3 September 2021

**Boco Rock Wind Farm Modification 1 (MP09_0103-Mod-1)
Biodiversity Assessment**

Figure 3 Proposed Modification to WTG dimensions

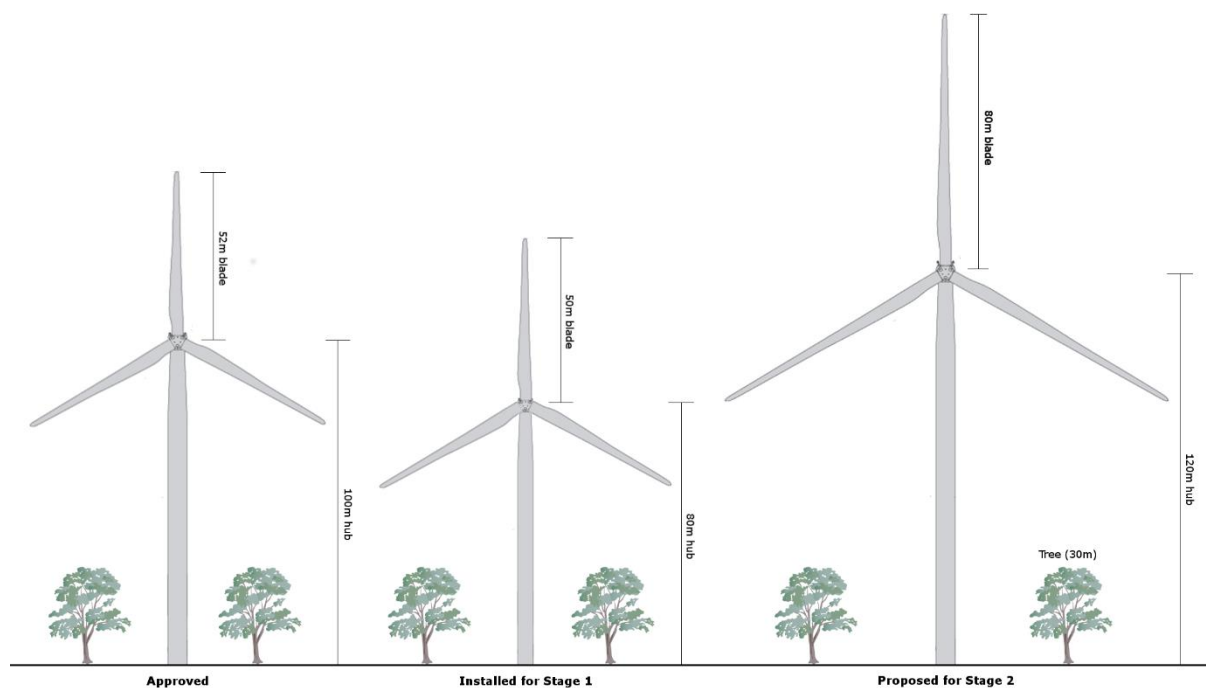
- **Flight path integrity** (BC Regulation clause 1.4(e)):
 - an assessment of whether the changes to turbine dimensions will increase or decrease impacts to high-flying aerial threatened species (such as White-Throated Needletail, Grey-headed Flying Fox, Large Bent-winged Bat and threatened raptors):

- based on strike estimates of all threatened species using data collected from the implementation of the Bird and Bat Monitoring Program from Stage 1;

- an understanding of ecology and behaviour of each impacted species (including flight paths and flight heights); and
 - predicting the:
 - rate and timing of strikes per turbine per year for each species;

- consequences of impacts for the persistence of populations; and
 - cumulative impacts of the proposed development alongside existing wind farms.
 - a map of significant landscape and habitat features within the disturbance zone of wind turbines (e.g. hollow bearing trees and raptor nests).
